Your Ref: OWPC6564
Our Ref: K/22/15/CLP 16-07-2015
Please ask for:
Ross Leal

Application for a Lawful Development Certificate for proposed extensions to ground floor & alterations

Broadbeach 39 Coastal Road Kingston

Proposed Ground Floor Plan
(alterations and extensions)

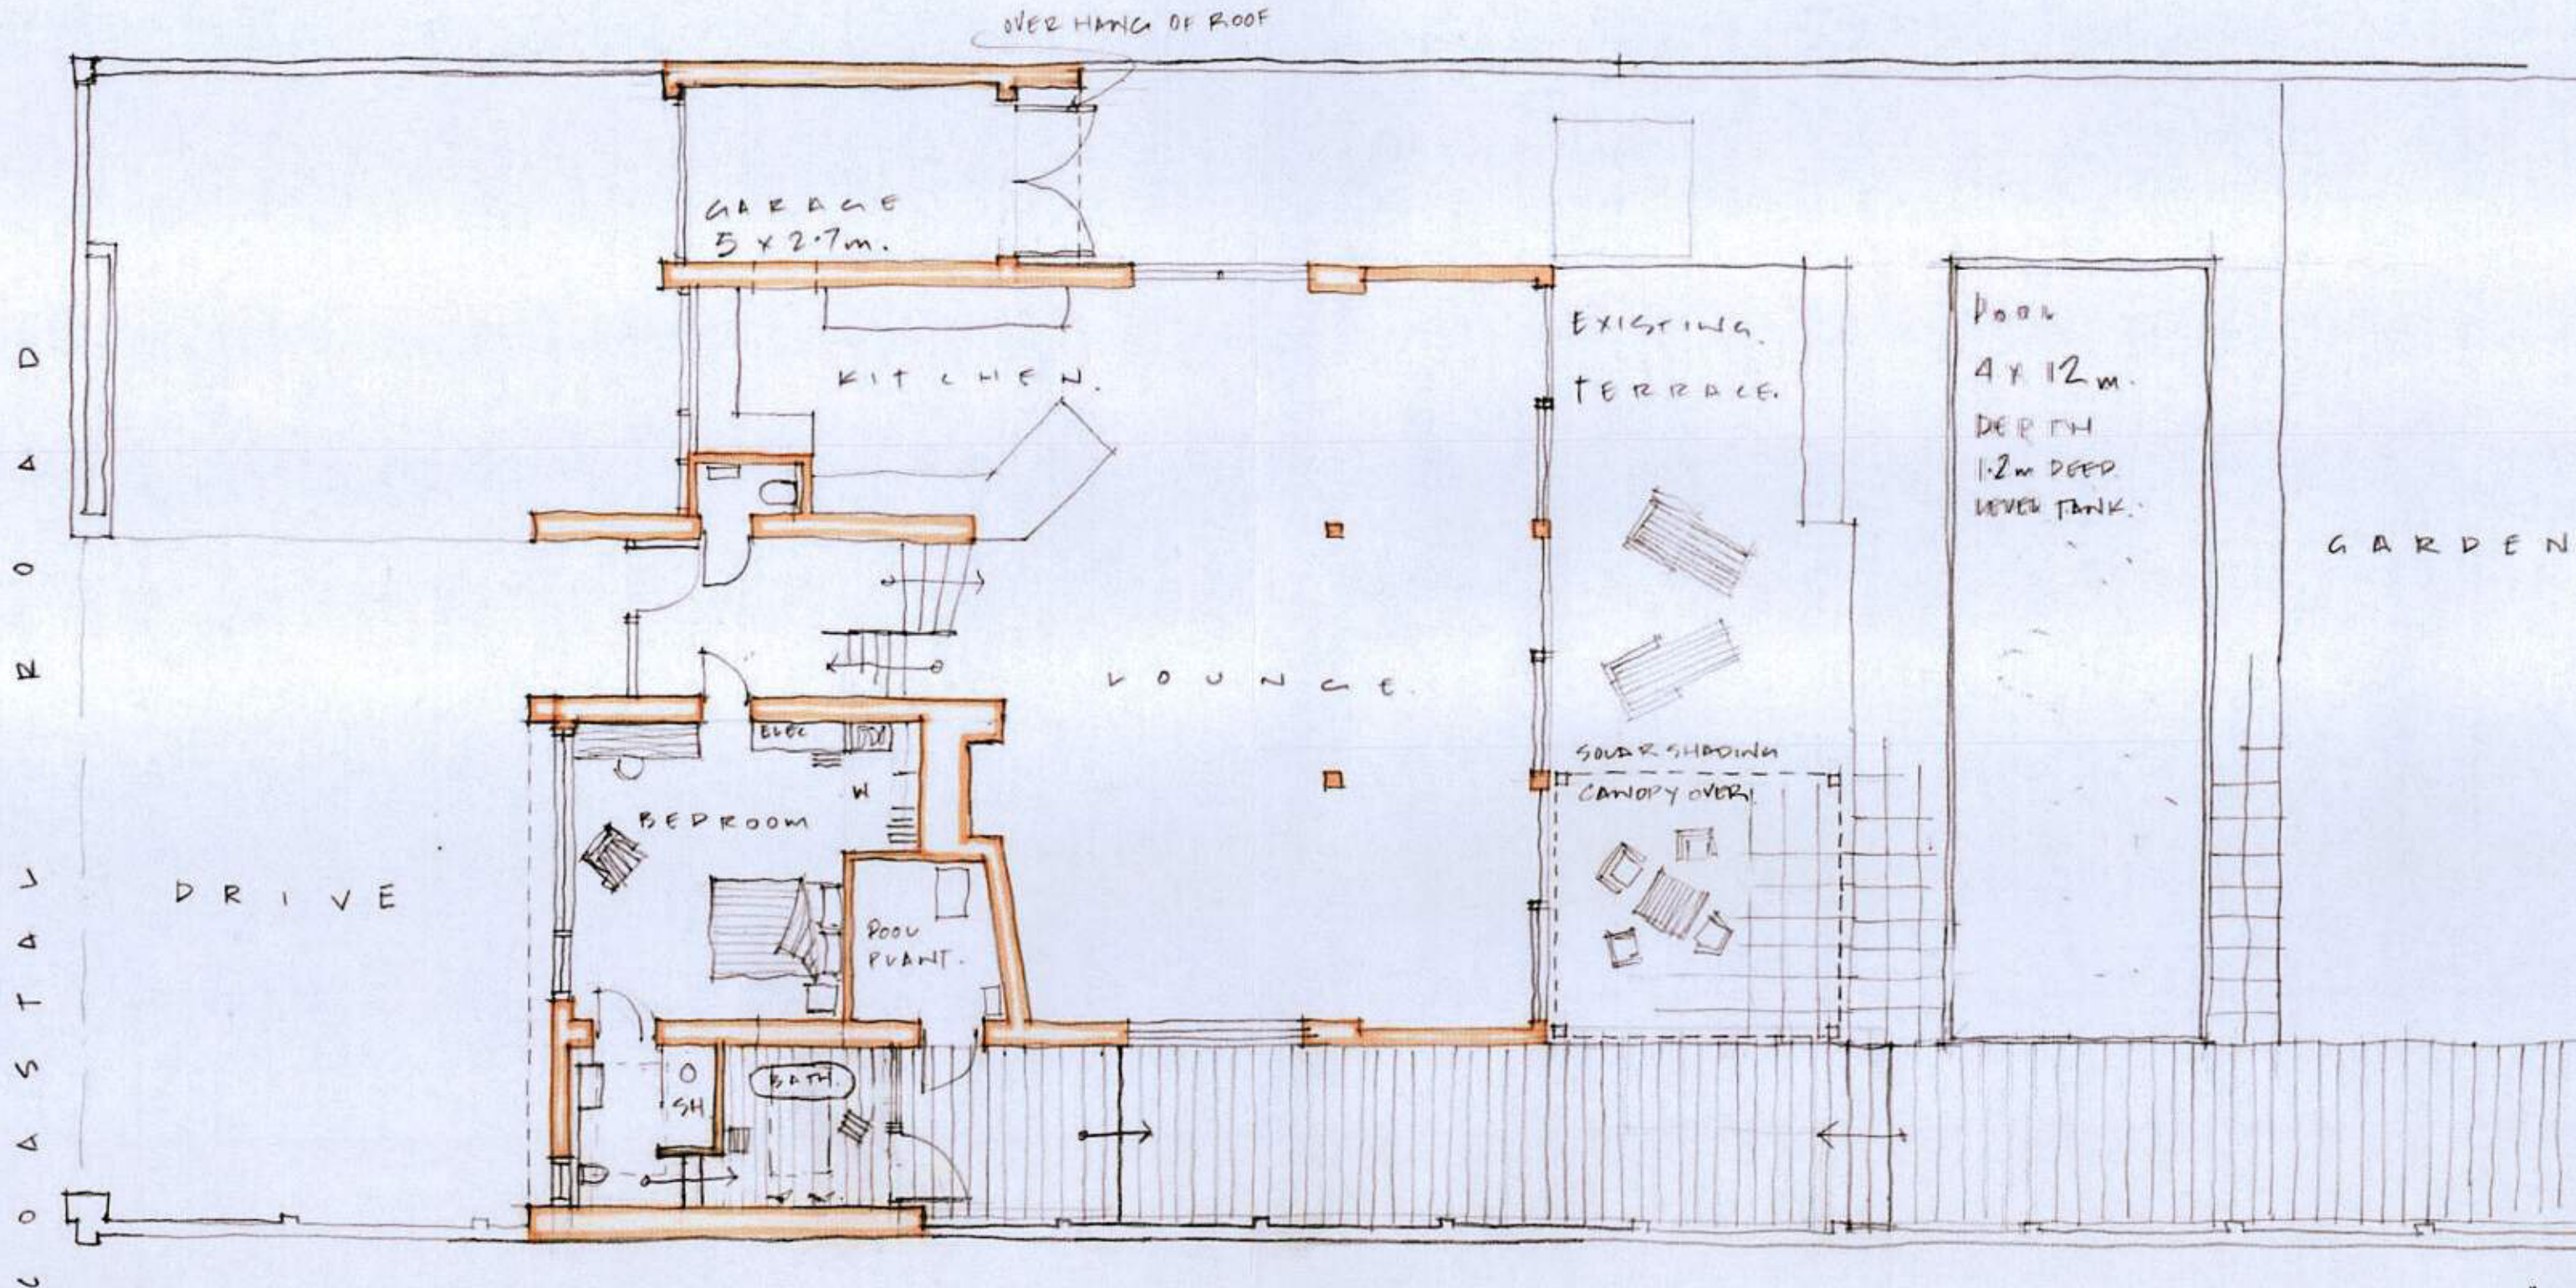
The flat roof at the front of the property is the smaller and lower of 2 flat roofs on the property and was part of the original property which was built in the late 1960s. This roof is approx. 2.6 metres in height and covers the porch, part of the interior entrance hall, and the front part of the integral garage including the garage door. The applicant proposes to raise the height of the part of this roof which is west of the porch to 3 metres as shown in the diagram of the "Proposed North Elevation". This clearly consists of an alteration to part of the roof, i.e. the application does not fall within the scope of Permitted Development.

Proposed North & South Elevation
 (alterations and extensions)

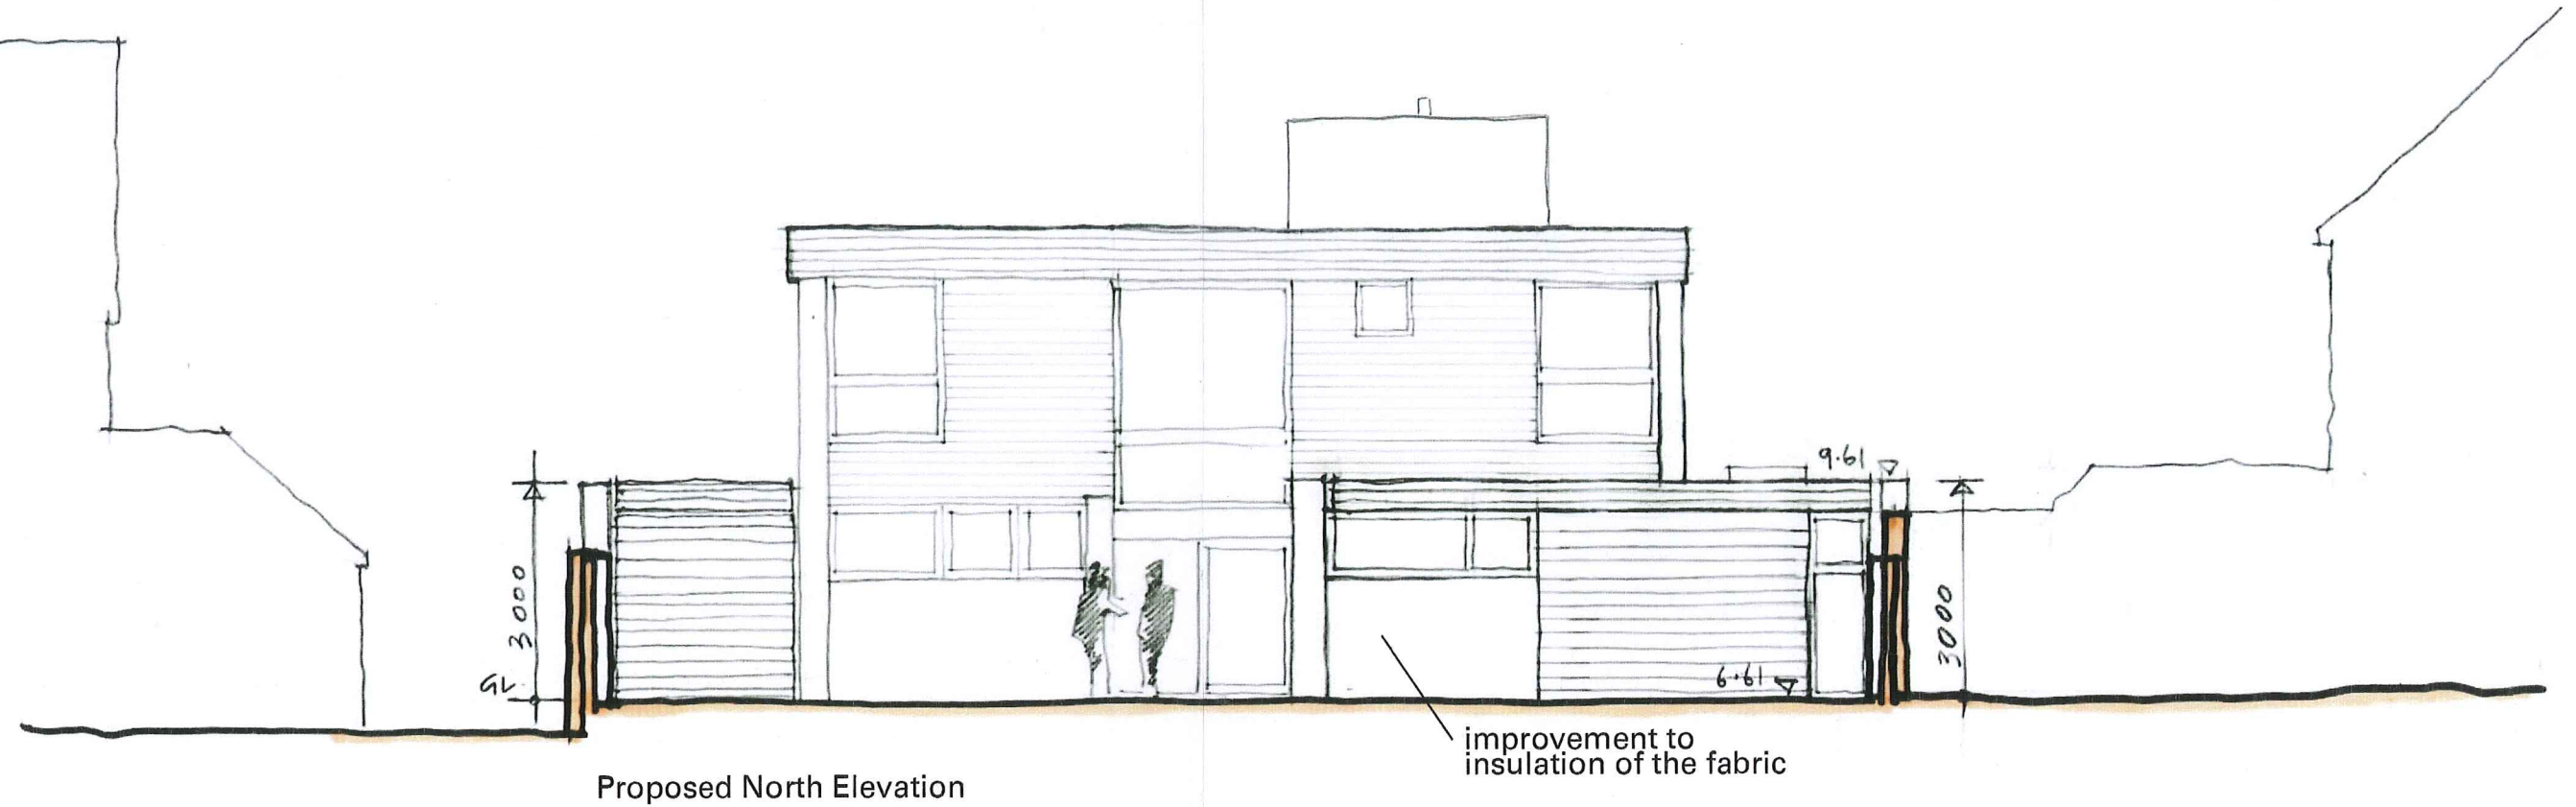
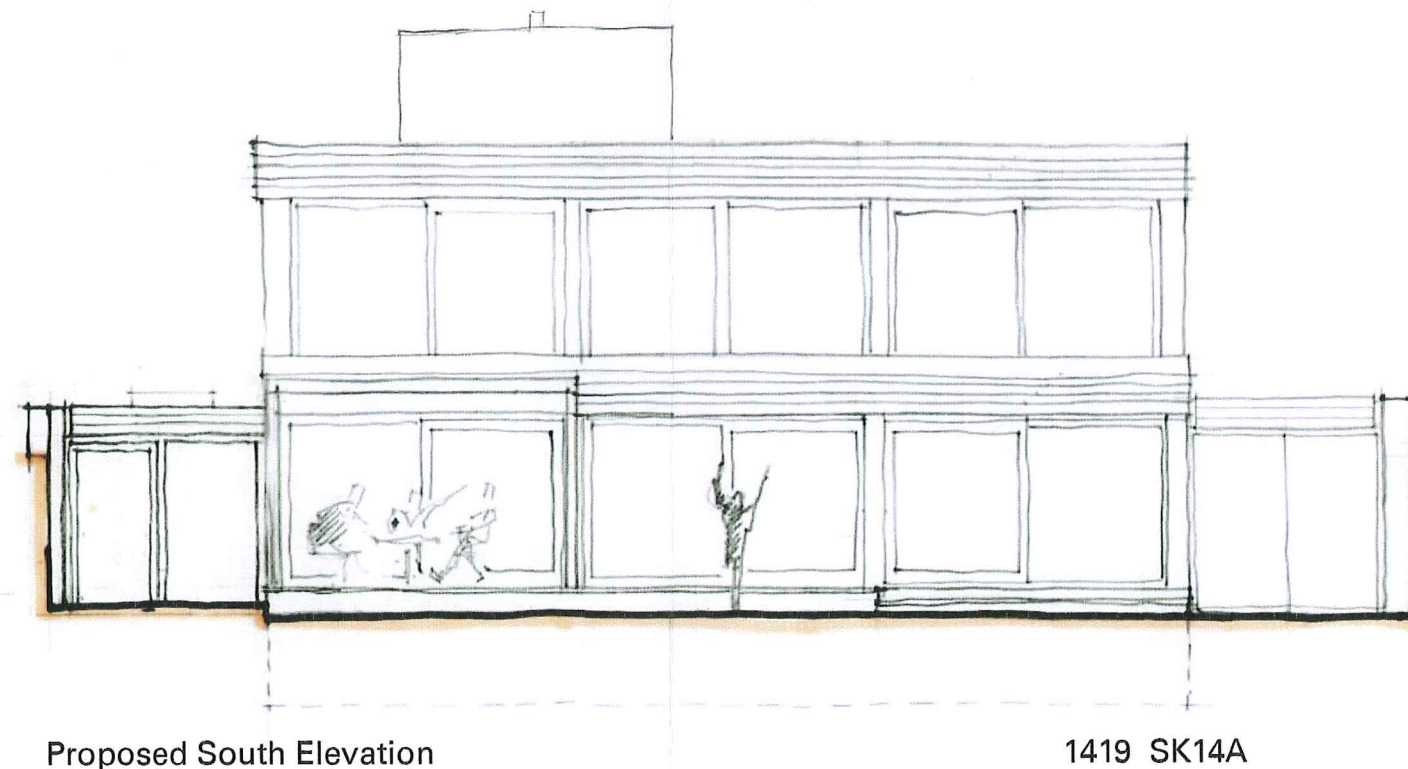
In other words, our understanding of the 2015 Order is that it would be within the scope of Permitted Development for the applicant to EITHER raise the height of the original first floor roof from 2.6 metres to 3 metres and to not join this up with an extension to the west side of the house; OR to develop a west side extension of a height of 2.6 metres and join this to the original roof - but NOT to do both of these as is being proposed. One of our main objections to the previous proposal was that a structure directly against, further forward than current, and protruding above our dividing wall would spoil the easterly aspect of our property. If the applicants had submitted a proposal which included either
